Recommendation Report for Planning Permission for Works or Extension to a Dwelling

REF NO: R/73/19/HH

LOCATION: 29 Tasman Close
Rustington
BN16 2BD

PROPOSAL: Single storey side / rear infil extension

PROPOSED PART
REAR ELEVATION

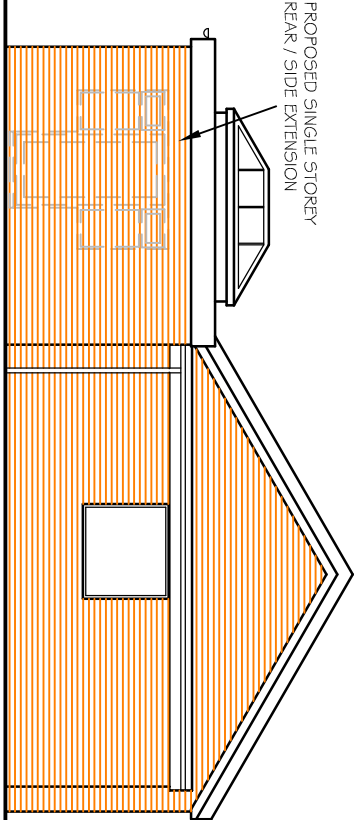
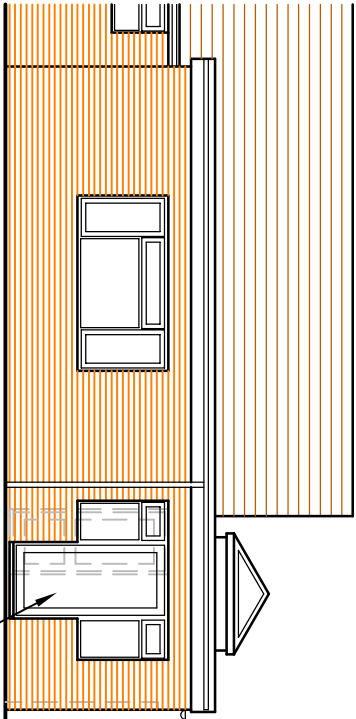
As a result of the siting of the host dwelling, the proposed extension will not be visible from the street scene. Additionally, the proposed development is considered to be an acceptable addition to the host dwelling, this is because it matches the eaves and ridge height of the existing garage, and uses matching materials. Therefore, the proposed development is considered to be well integrated with, and subservient to, the host dwelling. Therefore, the application is considered to be in accordance with D DM1, D DM4(a) and (b) of the Arun Local Plan, and Policy 2 of the Rustington Neighbourhood Development Plan.
